# Engineering Comment Responses

Project: Nguyen Residence  
Subject: Engineering Comments Permit #2204-199

C2.0

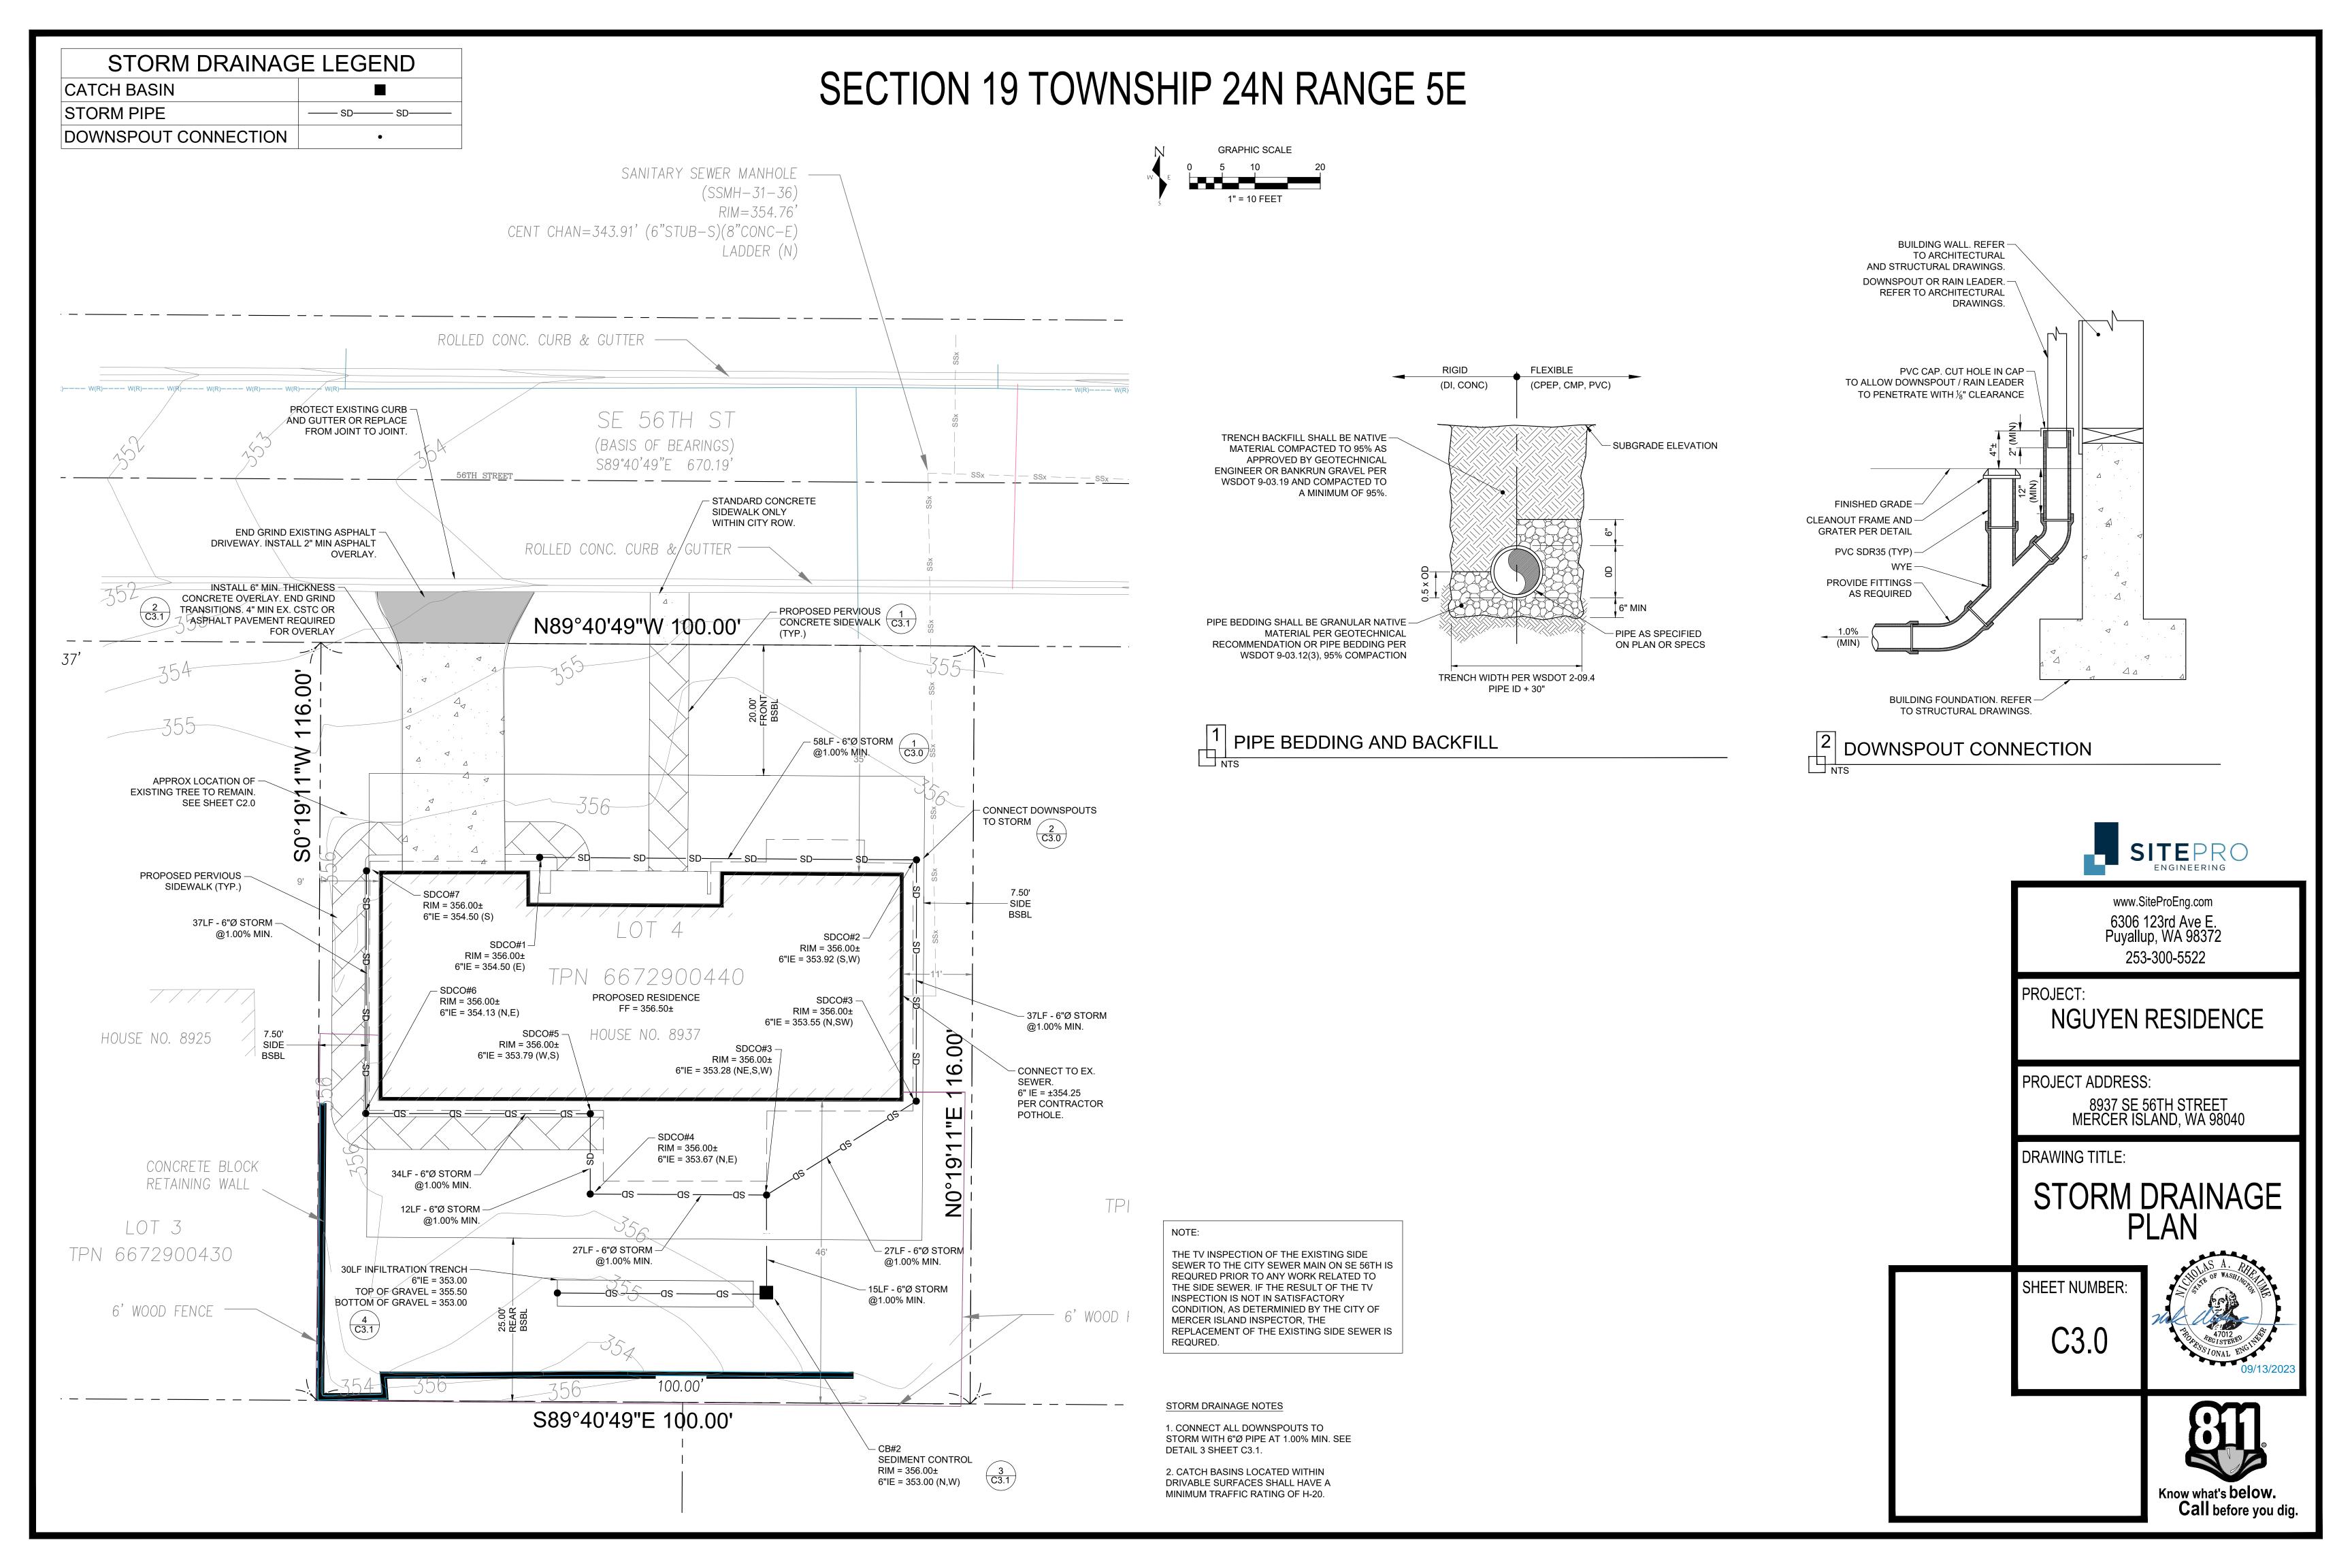
2. **Plan sheet C2.0** – Is the construction entrance intended? Architectural plans indicate existing driveway to remain and be protected. **It has been decided that the driveway will be overlayed for maintenance rather than removed. We have removed the construction entrance and added notes to sweep street if sediment is tracked offsite.**

STORM DRAINAGE LEGEND	
CATCH BASIN	■
STORM PIPE	—SD—SD—
DOWNSPOUT CONNECTION	•

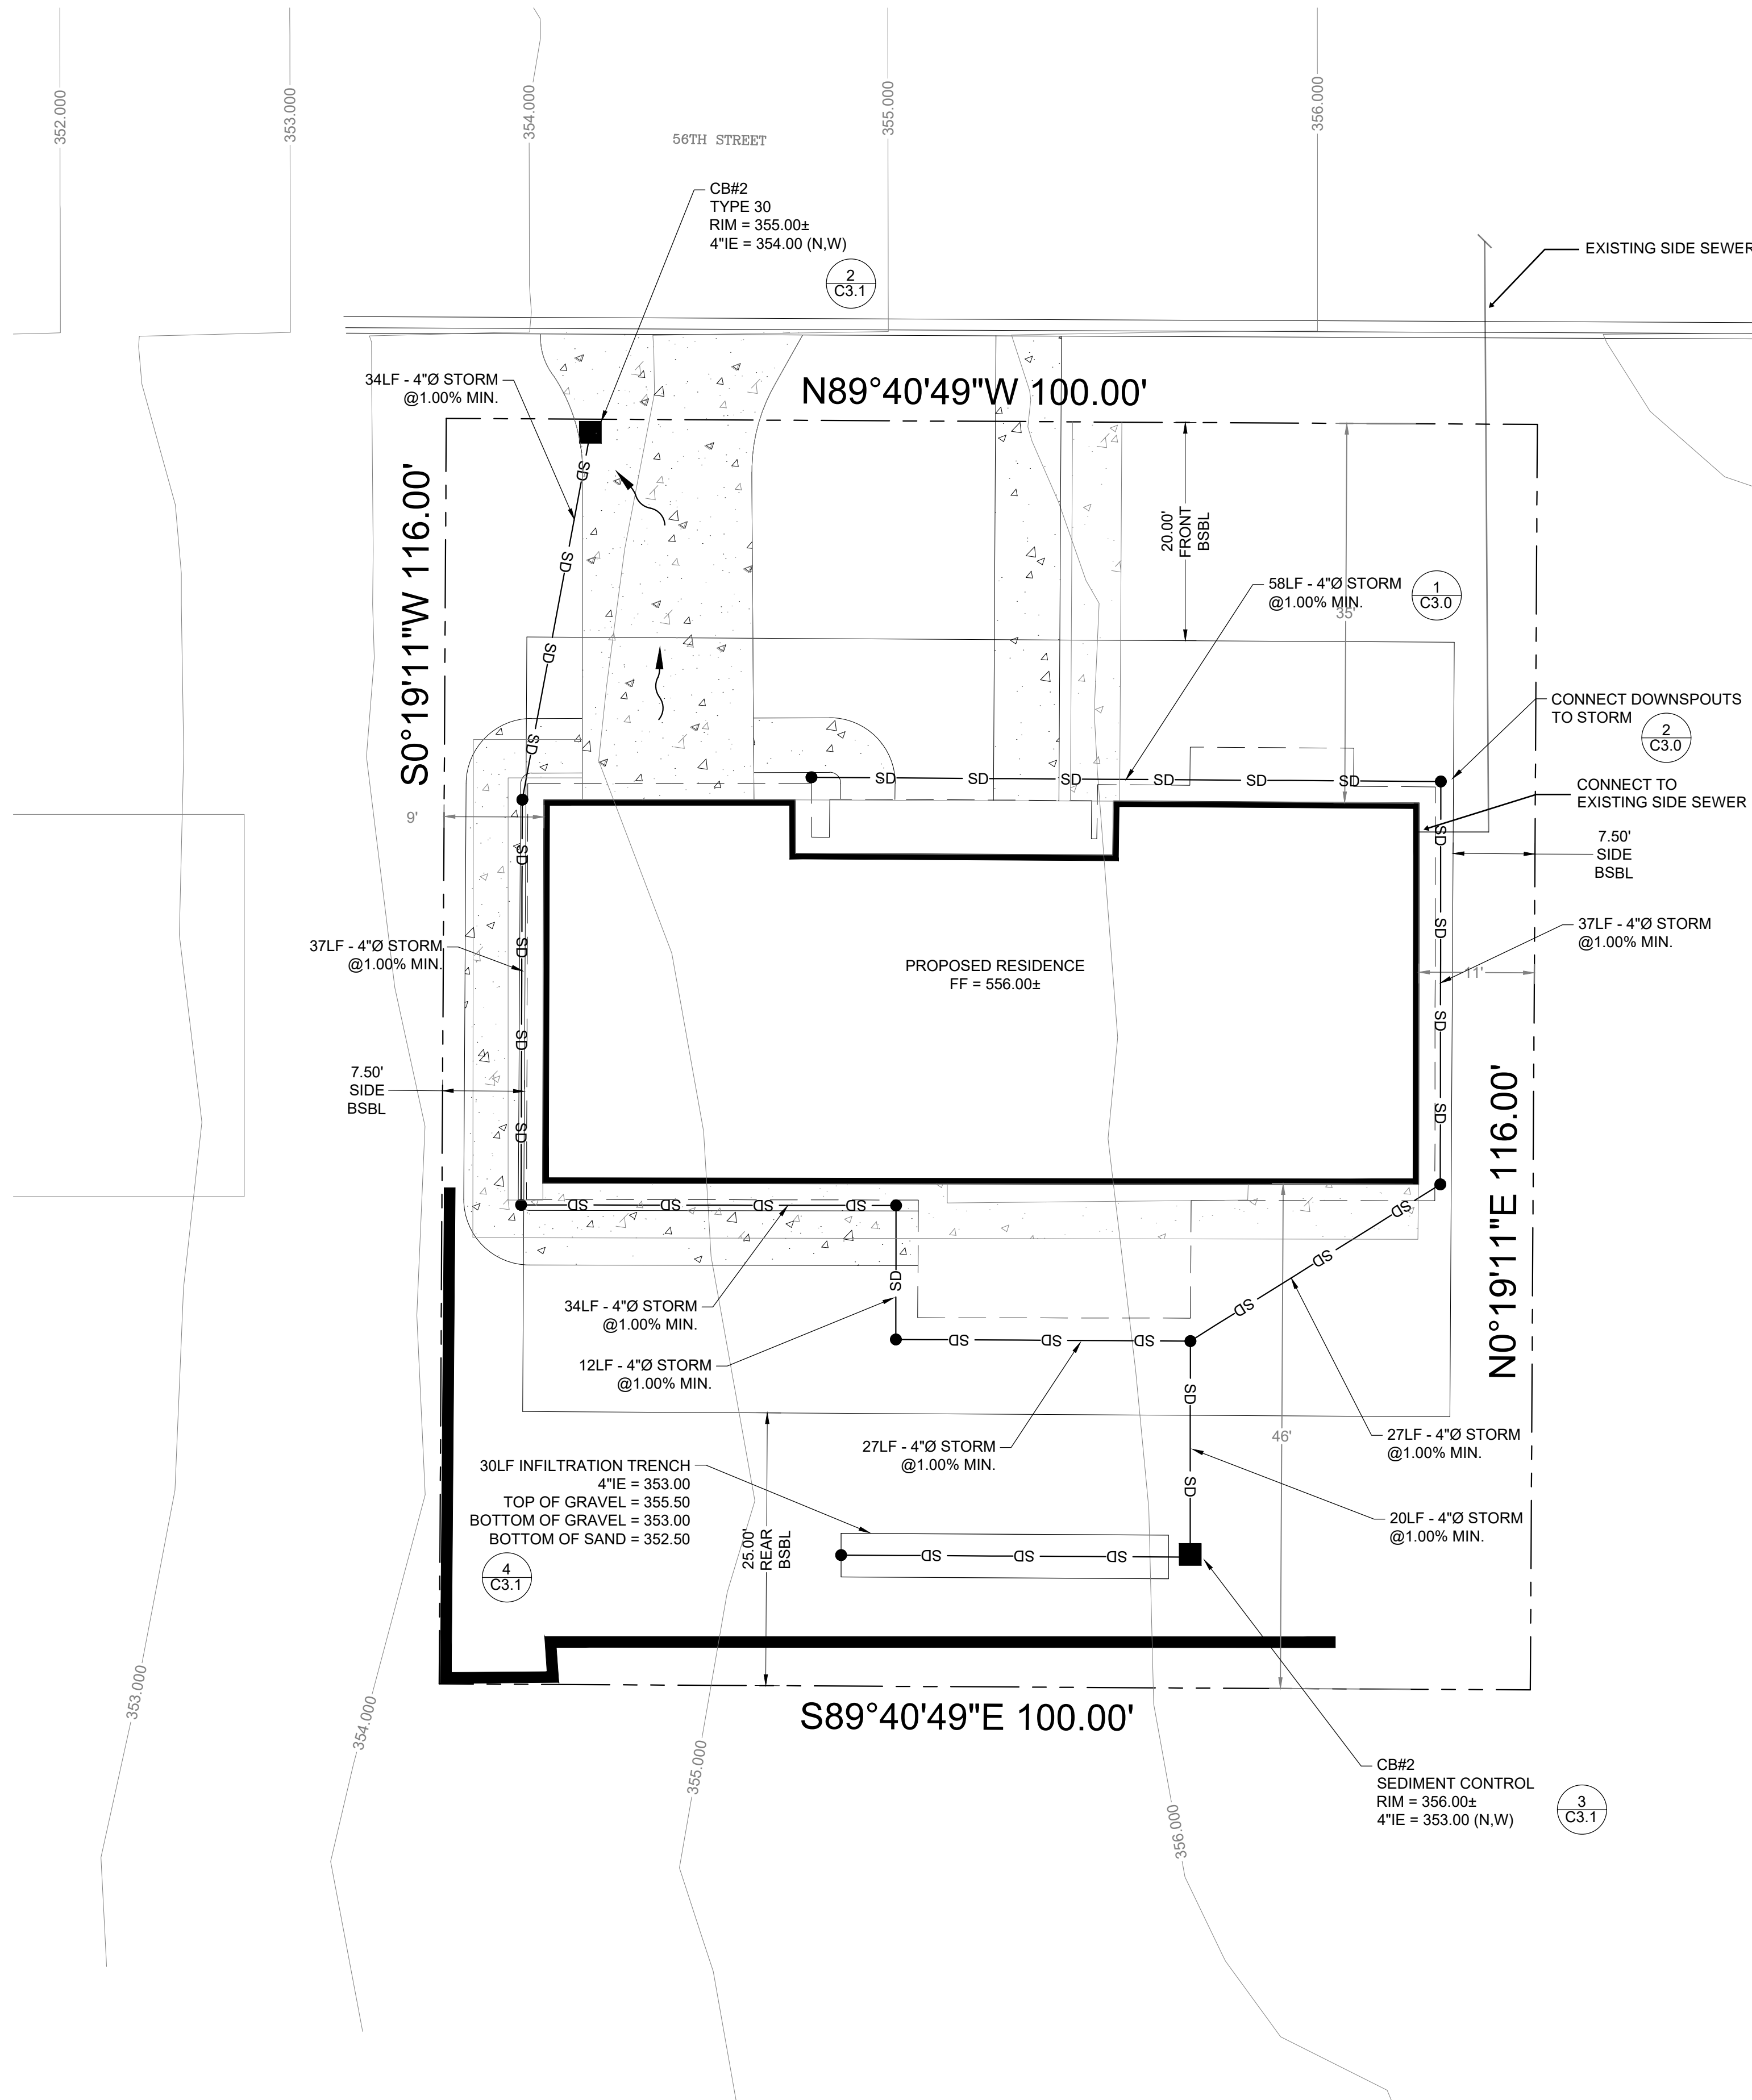
5. **Plan sheet C3.0 #3** – Indicate rims and inverts for all roof downspout/cleanout connection to show that there will be sufficient fall and pipe coverage – minimum 18” cover in soft surface/landscape, 24” cover in paved / drivable areas. **Added Rim / IE information as requested. We have utilized roughly 12” min. cover in soft areas, no pipe in drivable areas and are comfortable with this amount of cover in order to provide 1% min slope on the 6” pipe.**

15. **Plan sheet C3.0 #13** – The site plan callouts indicate 4” pipe @1% min, and detail 2 for downspout connection indicates 0.50% minimum – which is it? 4” pipe shall be 2%
